Subject: BR/304/19/PL - 9-11 Water Tower Buildings, London Road, Bognor Regis, PO21 1PN

In response to the above application, please may EH comment as follows:

Title: Floor Plans & Front Elevation
As Existing

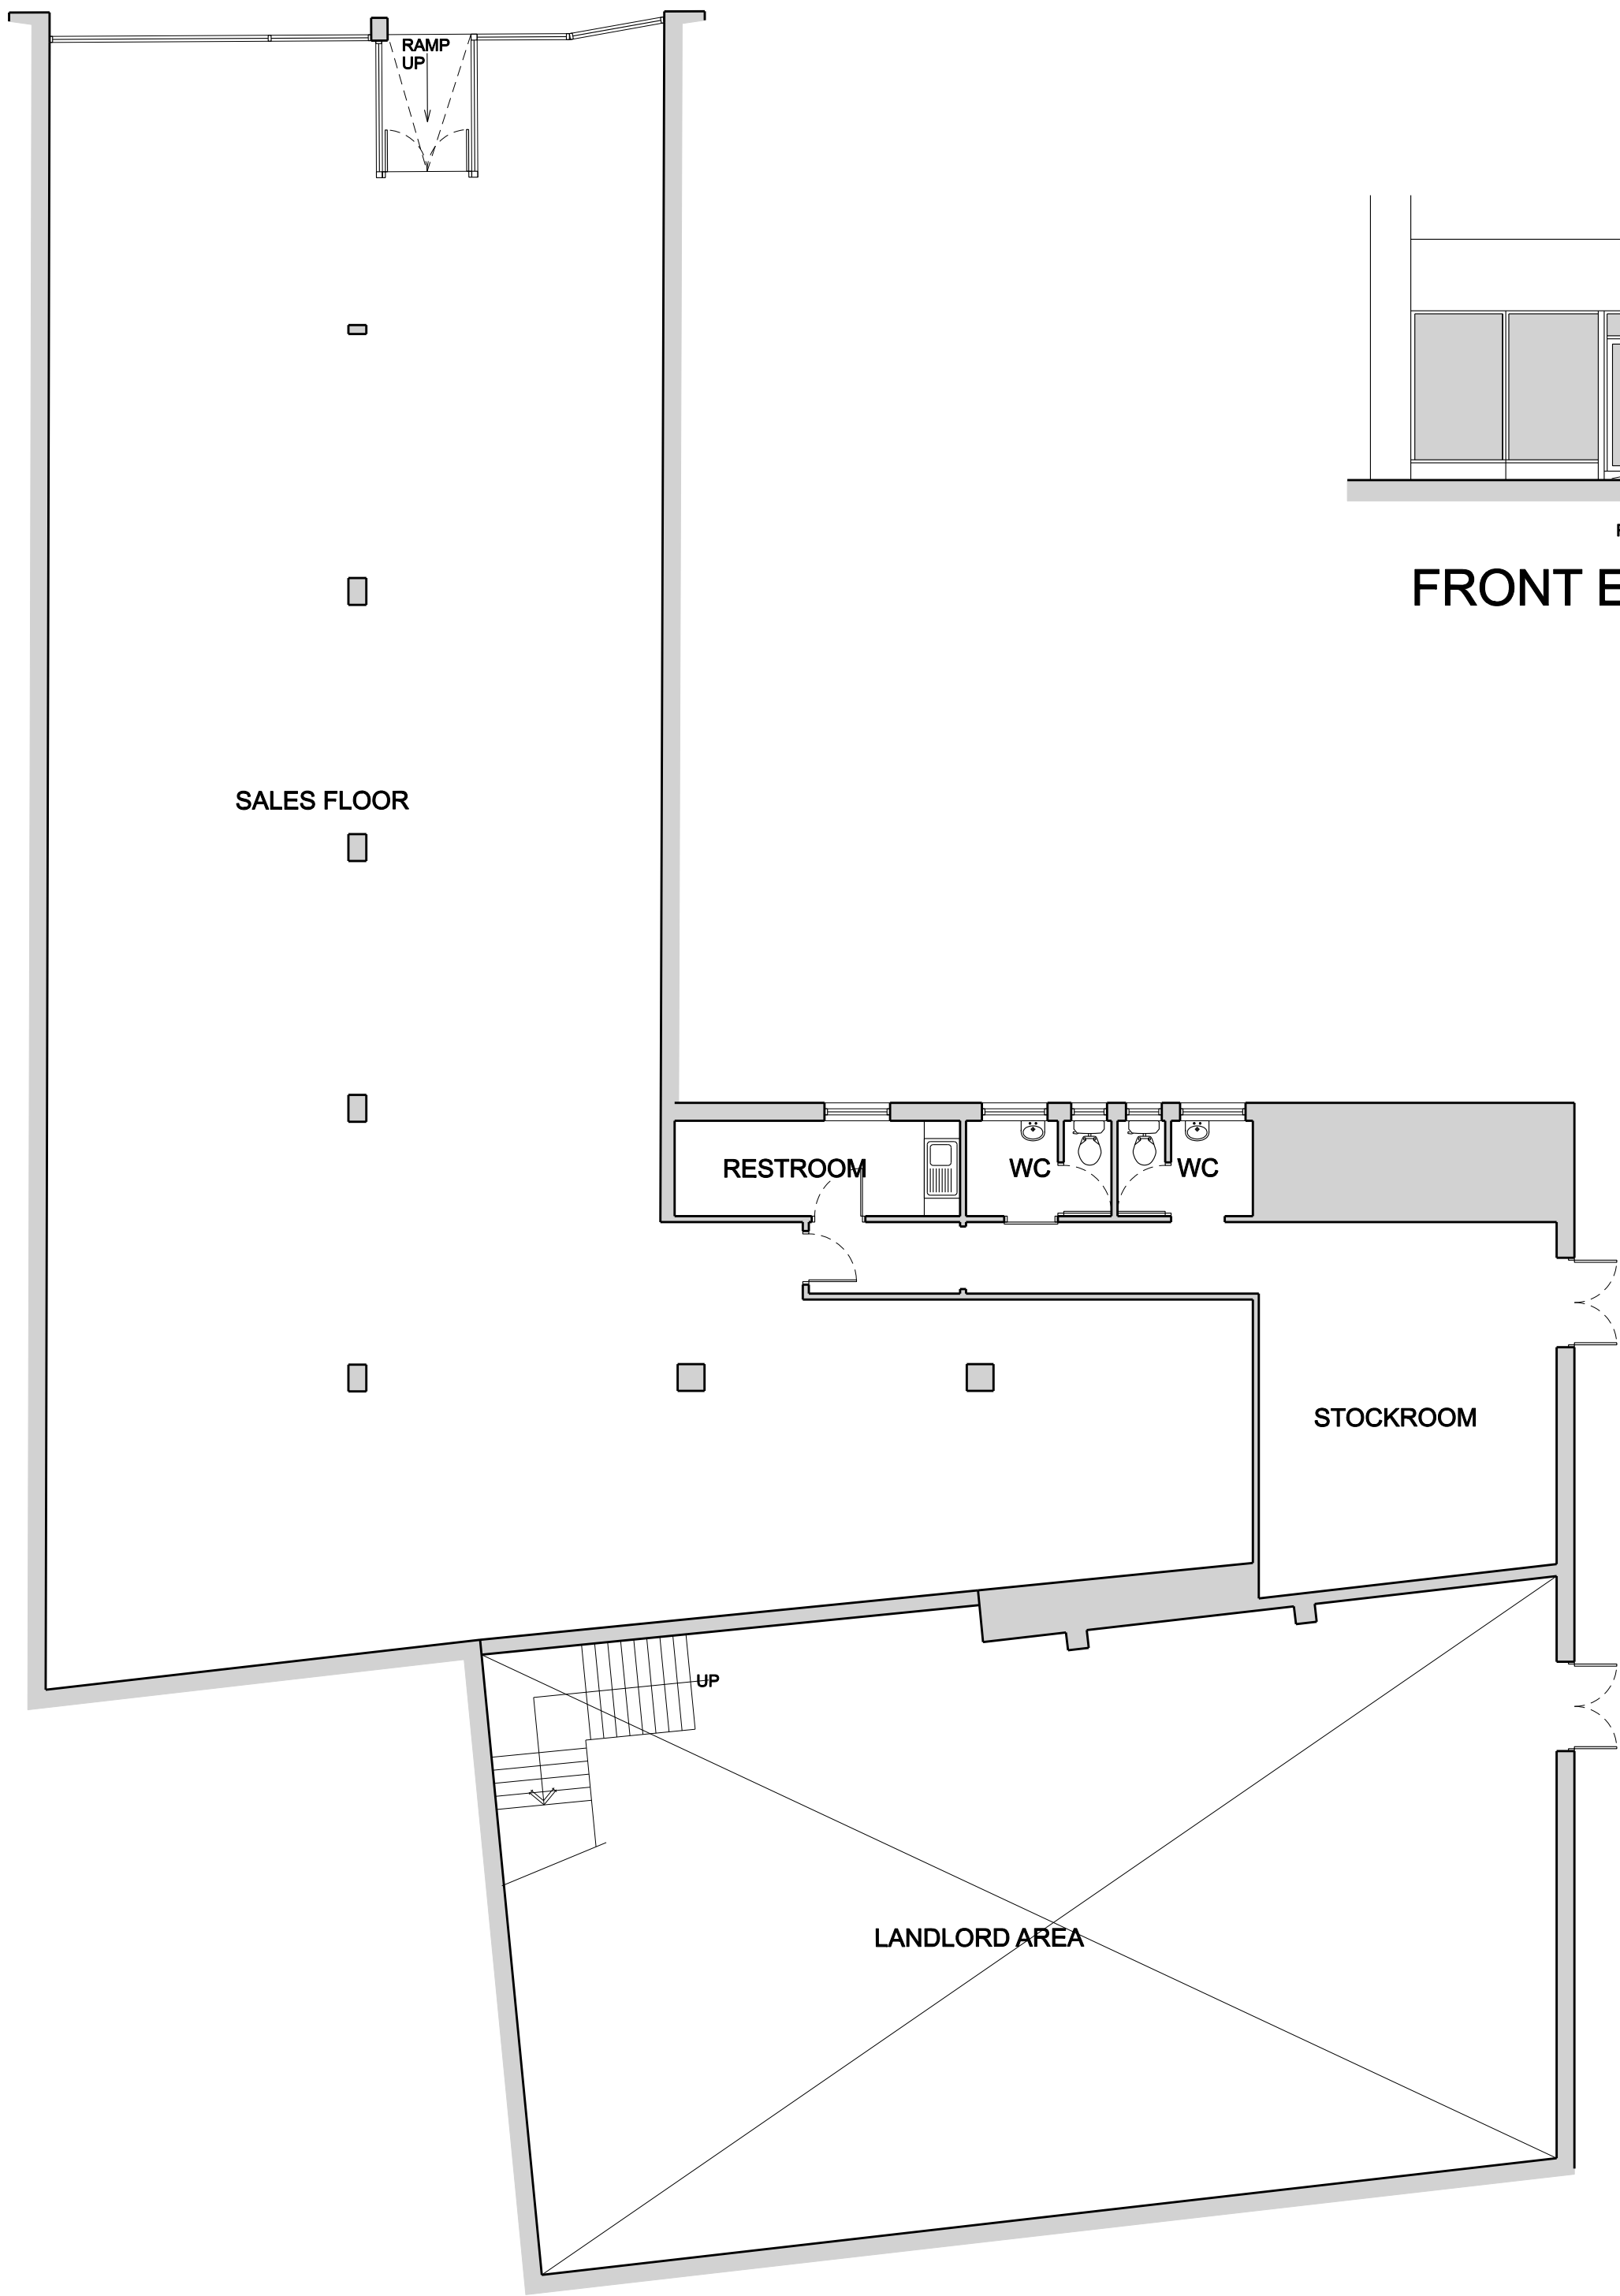
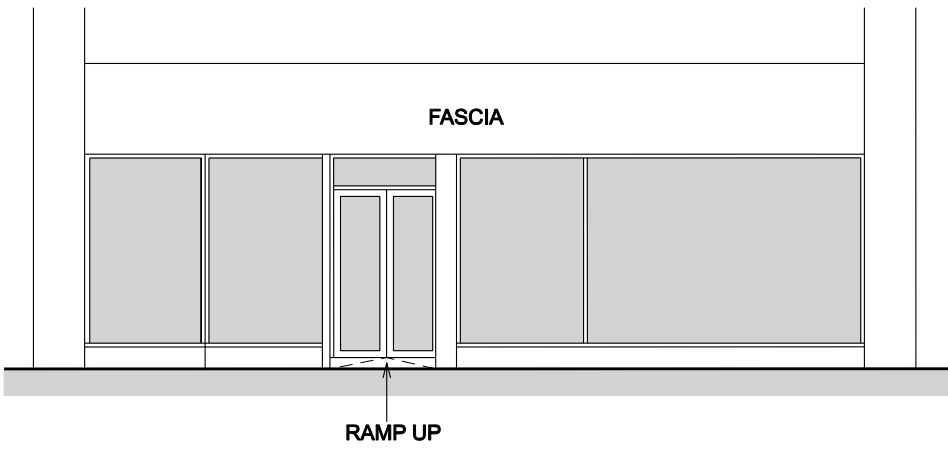
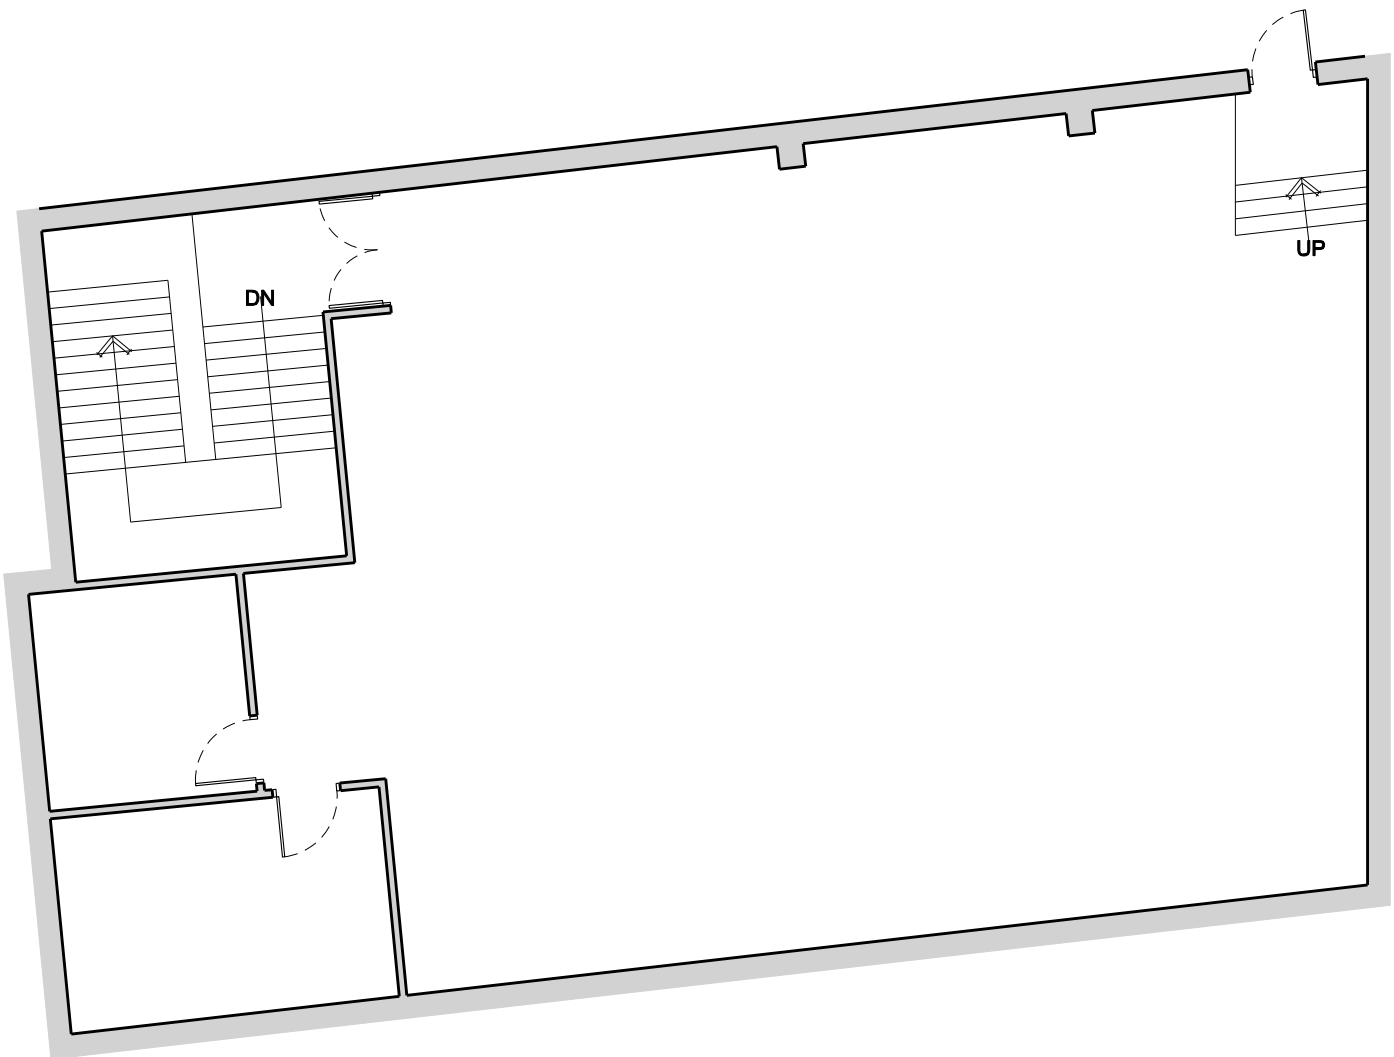
- please may the applicant confirm whether the proposed aluminium and glazed door(s) are the only feature or will security doors/roller shutters also be installed?

Title: **Ground Floor Ceiling/Lighting Layout
As Proposed**

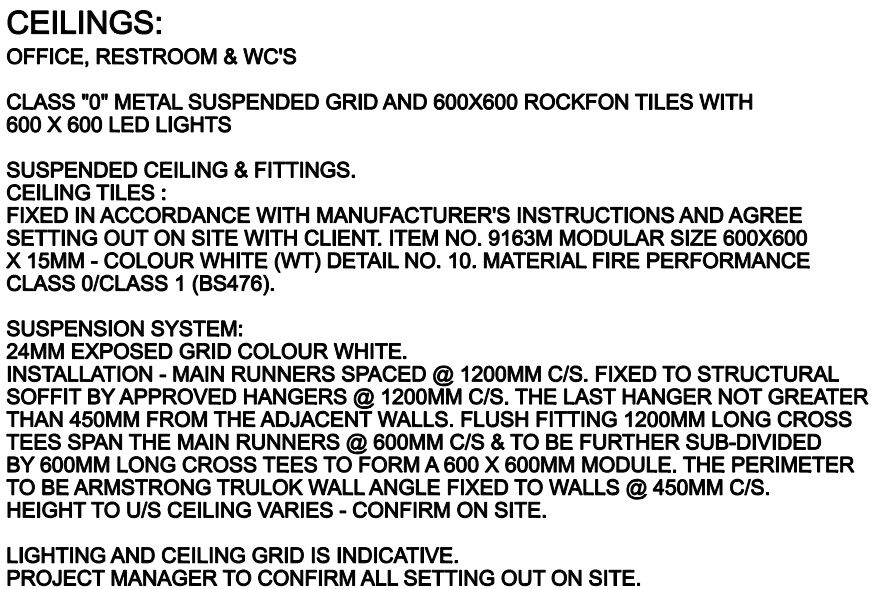
- No external lighting shall be installed until details have been submitted to, and approved in writing by the Local Planning Authority prior to the commencement of the development. This submission shall include a layout plan with beam orientation and a schedule of light equipment proposed (luminaire type, mounting height, aiming angles, luminaire profiles). The approved scheme shall be installed, fully assessed by a competent individual when operational to ensure no light creep/bleed, maintained and operated in accordance with the approved details unless the Local Planning Authority gives its written consent to the variation. **Reason:** To protect the appearance of the area/the environment and wildlife / local residents from light pollution.
